Your ref 3/2012/0210  
Our ref OCE/EVP/ER/3/10/8435/LK  
Date 8 August 2012

**APPLICATION NUMBER 3/2012/0210**  
**BACK LANE FARM, BACK LANE, CHIPPING, LANCASHIRE, PR3 2QA**  
**GRID REFERENCE 362172 441662**

The proposed development is for the erection of a new general purpose agricultural building for livestock housing and general storage.

Project No: Pot/546/1420/03

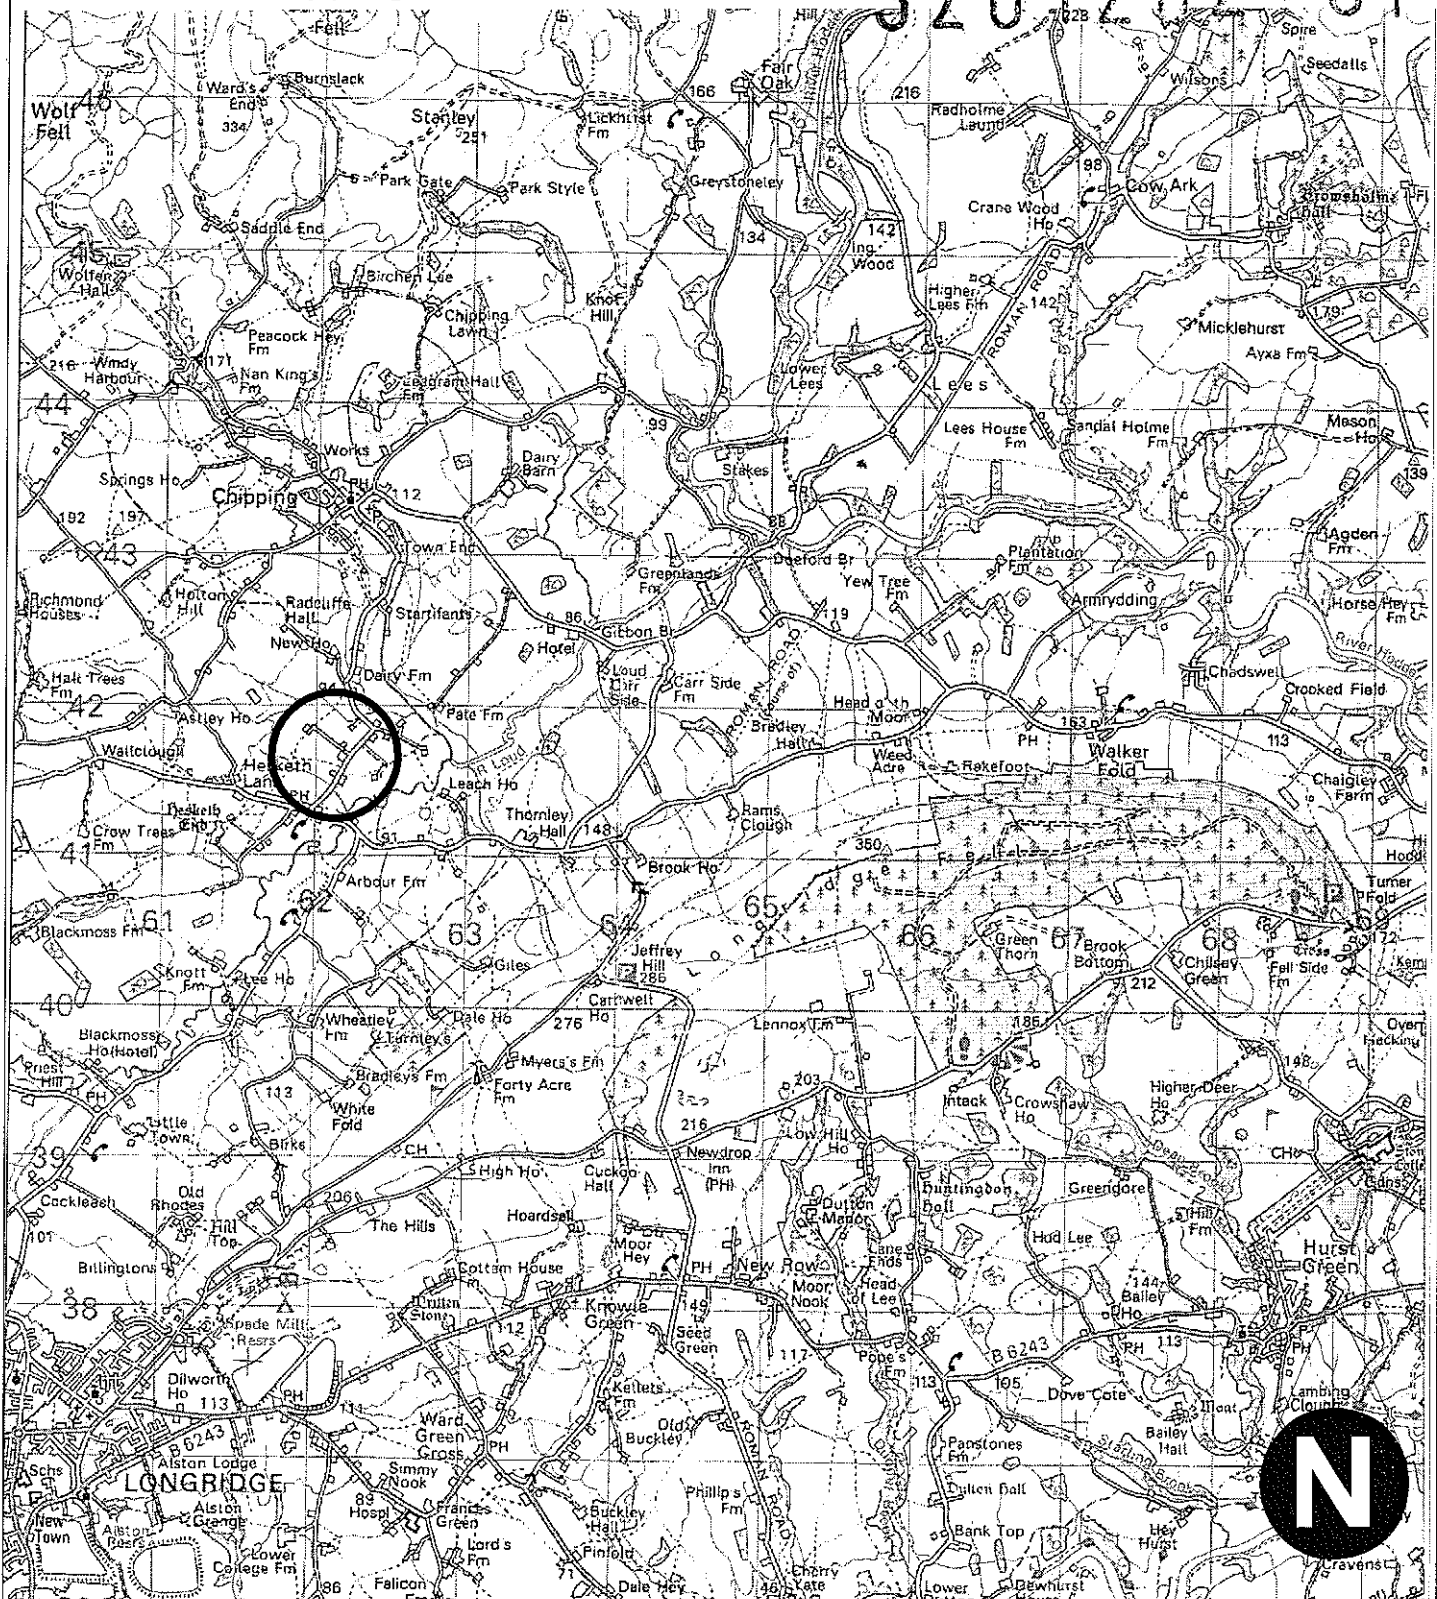
In terms of the size of the proposed development, taking into consideration the above, in addition to the land and existing buildings situated at Back Lane Farm, I am of the opinion that the proposed development is larger than necessary and the building could be reduced significantly whilst still serving the justified needs of the unit. Should the applicant have a registered flock of 20 breeding ewes, I would still consider the proposed development to be significantly larger than necessary.

With reference to those items of machinery that the applicant intends to store, it is my opinion that not all of the items listed, such as a roller, trailer and chain harrow need to be stored undercover and only those items such as the applicant's tractor and loader need to be stored within a building

The building is to be situated on the footprint of the existing building, adjacent to the remaining buildings at Back Lane Farm. It is in my opinion that the proposed position of the building is situated in an appropriate position from an operational point of view considering the layout of the buildings at Back Lane Farm.
